A303 Sparkford to Ilchester Dualling Scheme TR010036

8.10 Draft Statement of Common Ground with Queen Camel, West Camel and Sparkford Parish Councils

STATEMENT OF COMMON GROUND

Version	Date	Status of Version
Rev 1	January 2019	Draft for Examination Issue

INSET F: EXISTING ROADS AND PROW TO BE STOPPED UP

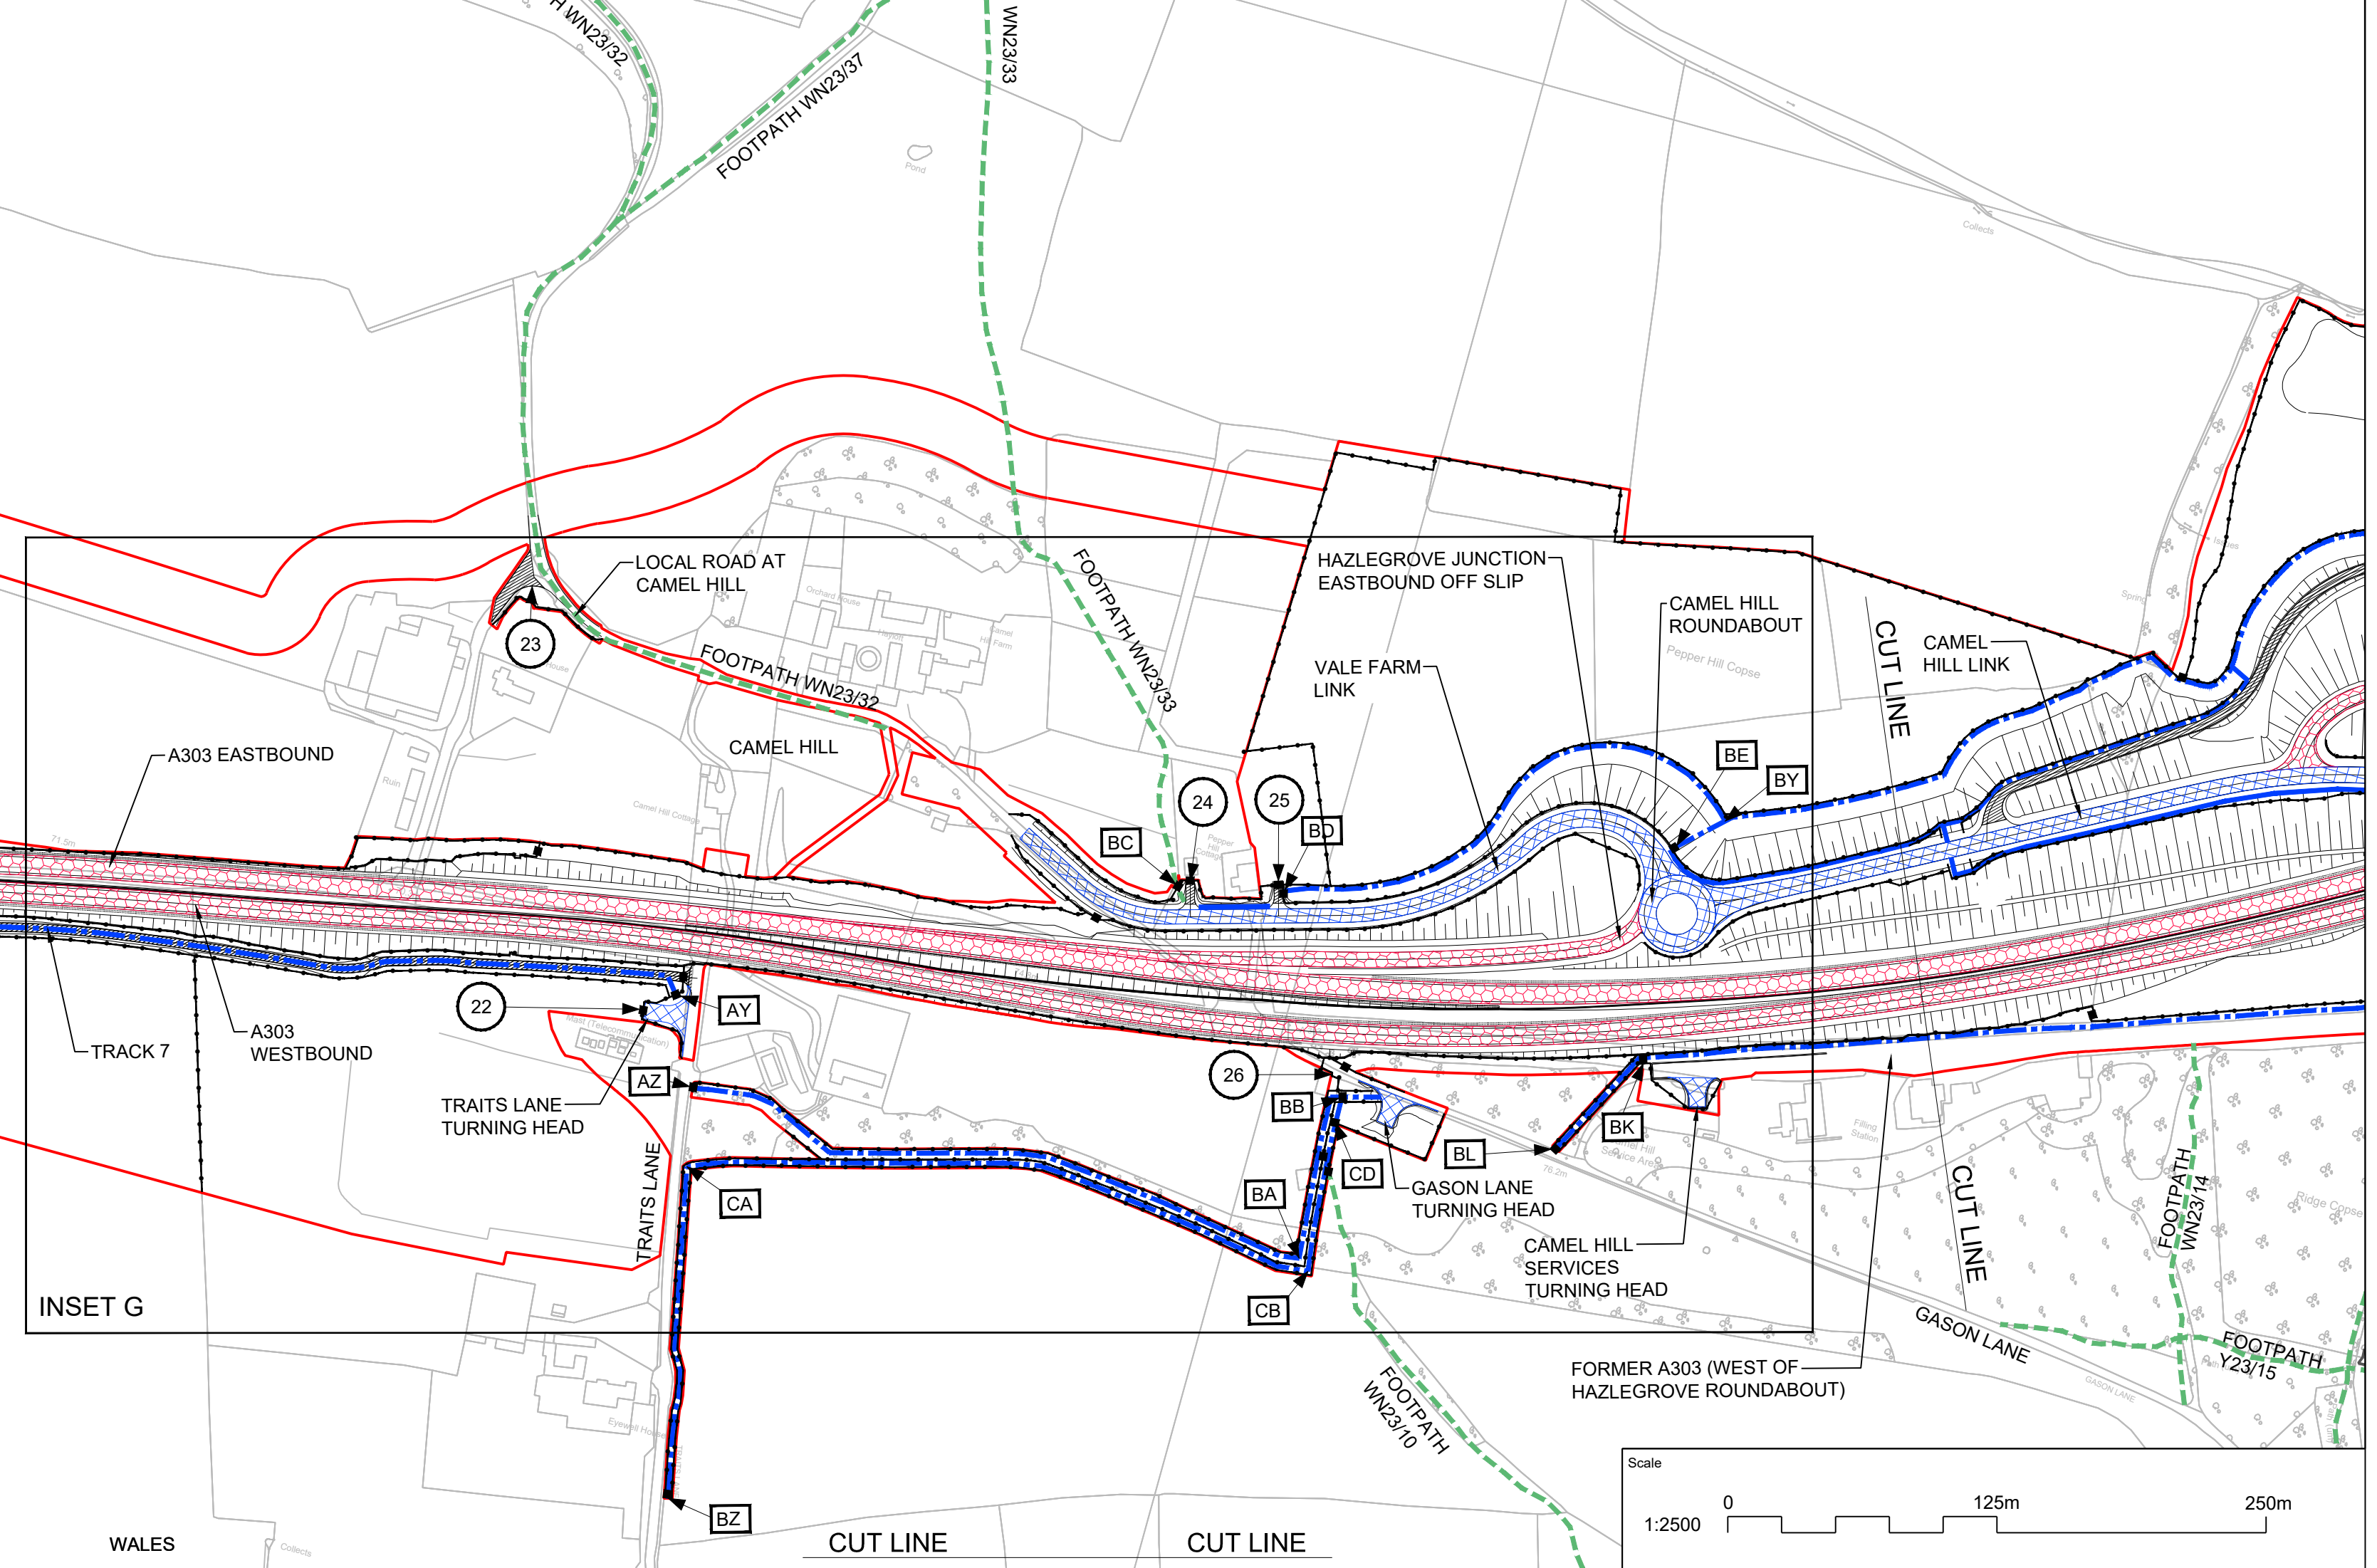
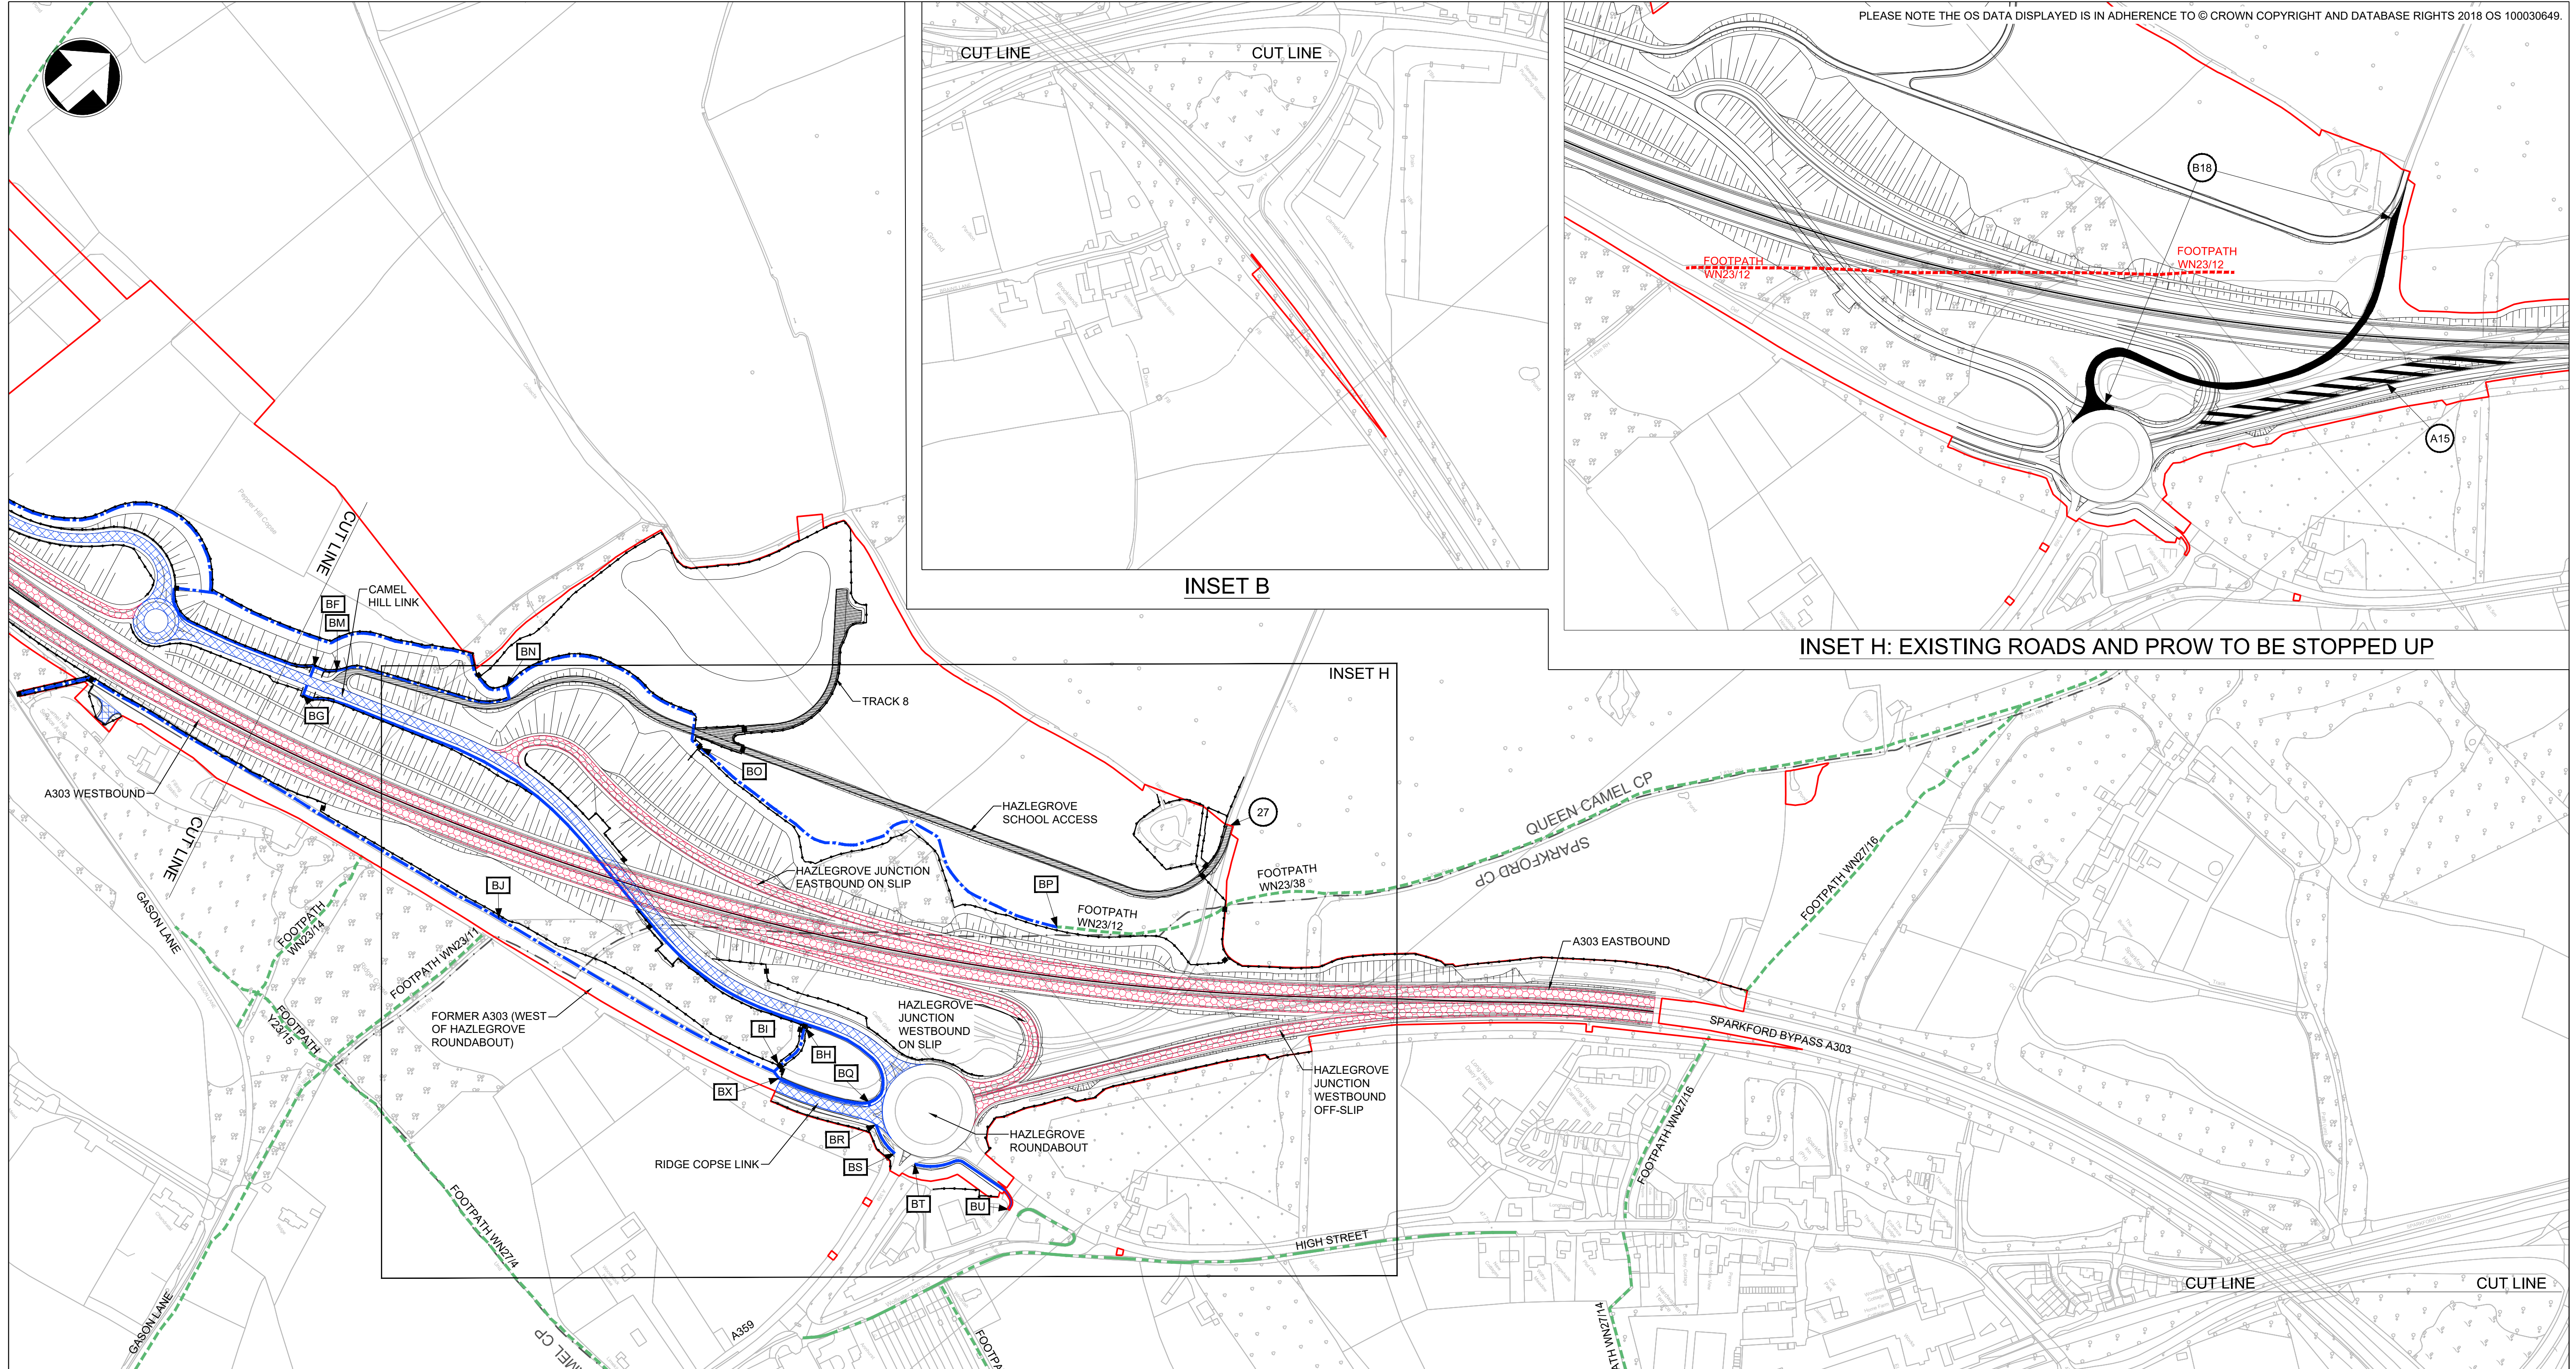
Public Rights of Way	The public rights of way will also be affected and protracted by the poor design of the Hazlegrove junction with walkers and horse riders forced to walk or ride along access roads to join rights of way within Hazlegrove park. Sparkford PC are still concerned with the poor design of the slip roads and that the under bridge will have no lighting during the periods of darkness.	A dedicated non-motorised user (NMU) route has been provided alongside the local road carriageway at the underbridge. This route will be segregated from motor traffic. It has been provided on the southern verge of the local road deliberately in order to avoid crossings of the eastbound merging slip road and the Hazlegrove School access.	UNDER DISCUSSION
